Sign Permit Application-55 Riverside Street

June 14, 2012

Re: 1199 Congress Street – 078 A001 – B-1 – Permit #2102-06-4167 & 55 Riverside Street – 266 A003 – B-4 Permit - #2012-06-4166

SIGN 7

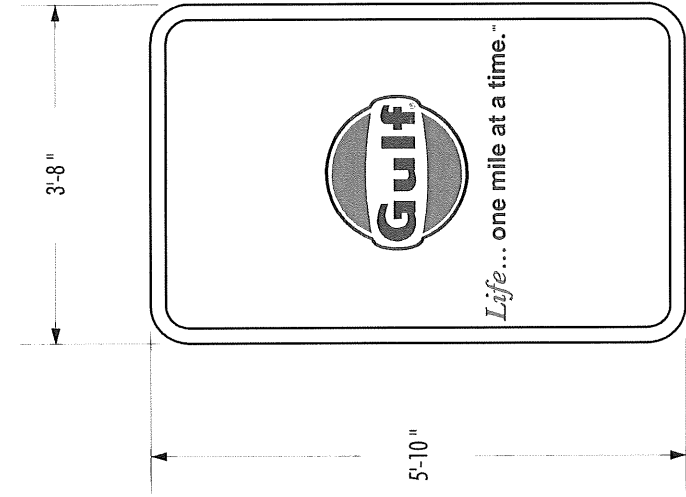
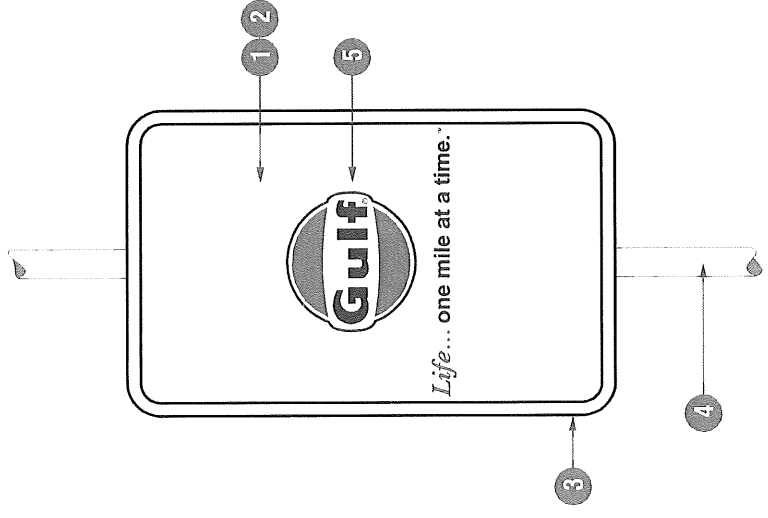
- The three Energy North signs are legally nonconforming but they are the same size as what has been permitted before, so they can be permitted.
- The two panels can be replaced in the pylon sign, but I question the dimensions that you have given. They have changed slightly from the sign permit for the pylon sign that was issued last year (2011-12-2856).
- Two canopy signs are allowed but the maximum square footage per sign is 20 sf. Each proposed canopy sign is 48sf.
- The 70" x 44" Clipper Mart sign on the light pole was not permitted. It cannot be replaced. Only one freestanding sign is permitted per lot.

Front View

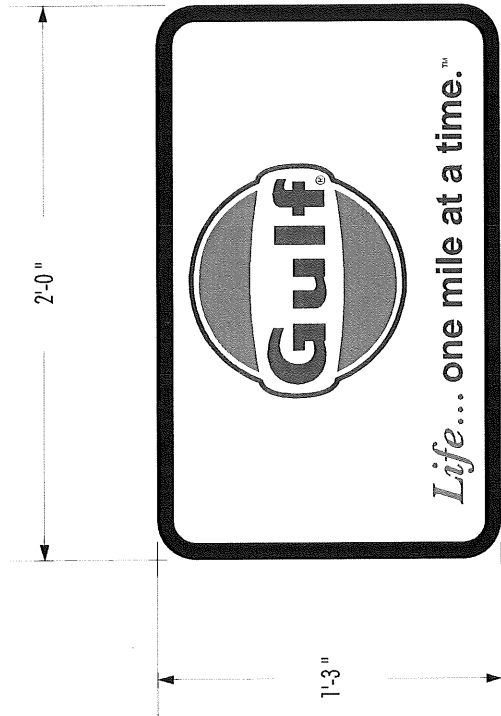
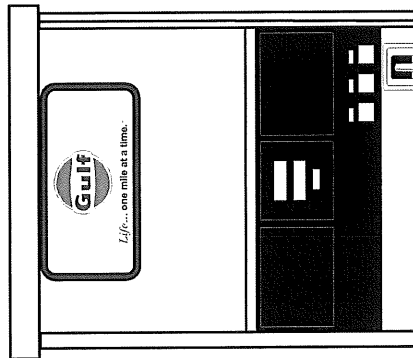
1. Under section 14-369.5, Table 2-14, "Signs placed on individual pumps shall be considered incidental signs and shall not be calculated in total allowable sign area. Incidental signs should not be limited in number. However, no individual sign shall exceed 1 sq. ft." The proposed pump signs do not need to be permitted, but they are too large to be incidental and must be reduced in size.

- Signs on individual pumps are incidental and don't need to be permitted but a sign can't exceed 1 sf.
